**Consultation Response from KC,
Highways Development Management****2024/91638 adj electricity sub station, Station Road, Bradley, Huddersfield, HD2 1UT****Erection of single storey storage unit with associated alterations****Date Responded: 22-7-2024.****Responding Officer: Mark Berry.****Responding Ref: 4-15SW-7.**

This application seeks approval to the erection of single storey 72 sqm storage unit with associated alterations at land adjacent to electricity substation, Station Road, Bradley, Huddersfield.

PROPOSED BLOCK PLAN
1:500

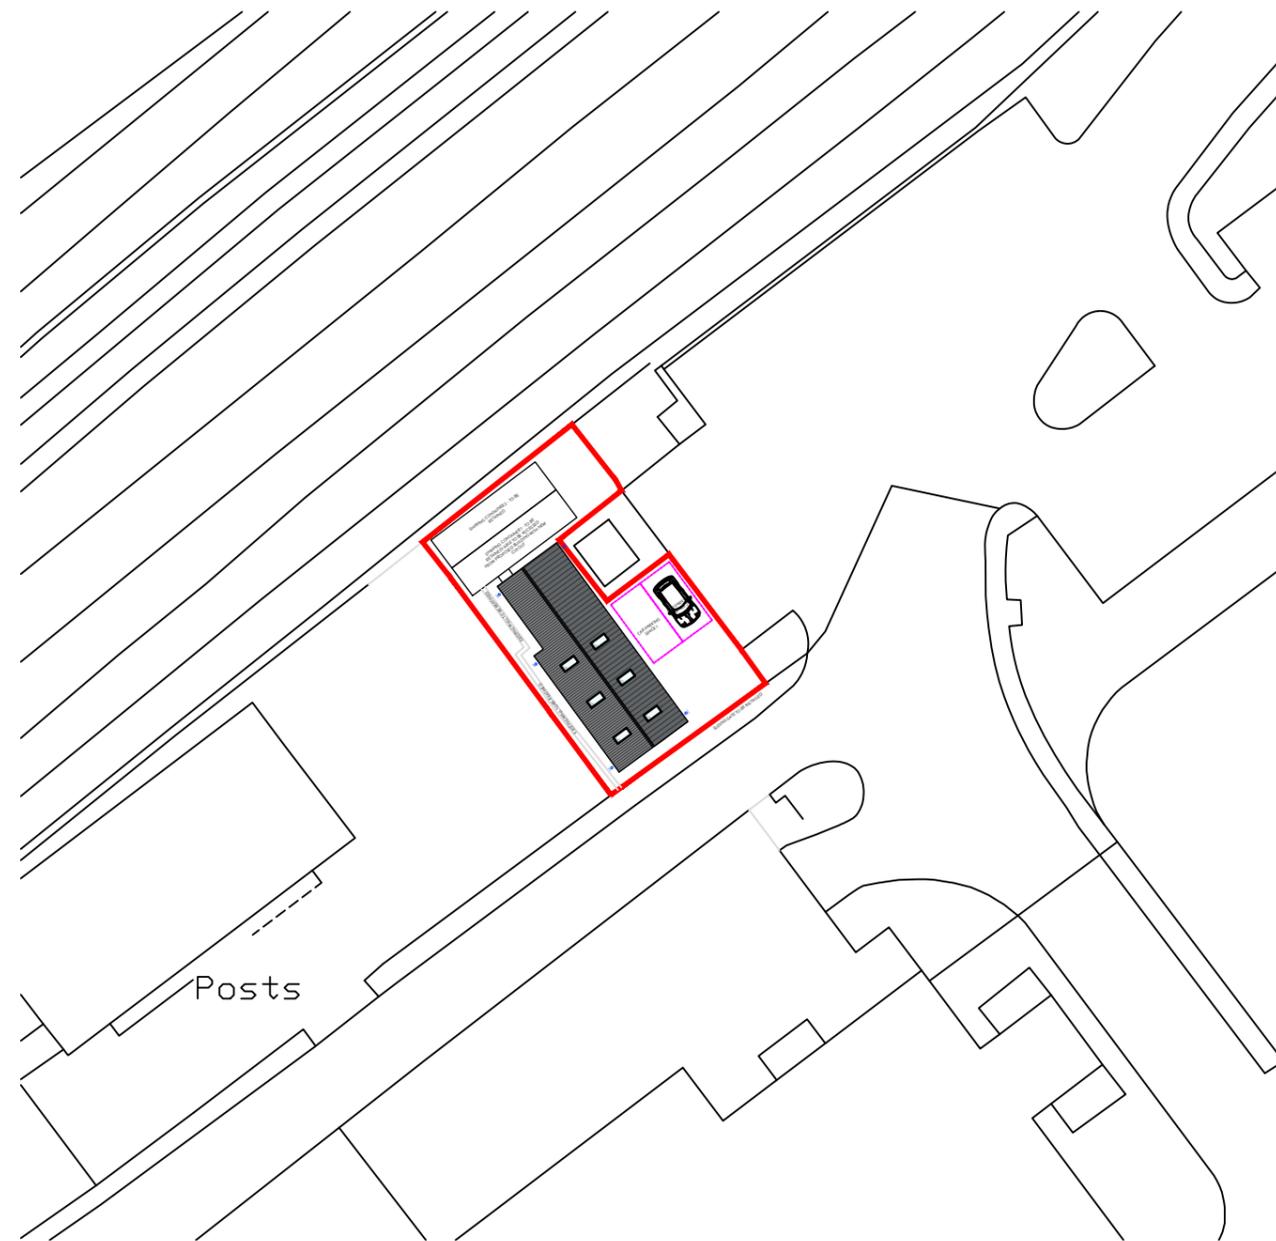
- 1, The proposed parking obstructs access to the roller shutter doors.
- 2, No vehicular turning is provided.

HDM will be unable to support this application unless the applicants can provide swept paths to demonstrate that the largest vehicle anticipated to visit the site can manoeuvre and turn and that independent off-street parking can be provided that doesn't obstruct the proposed access.
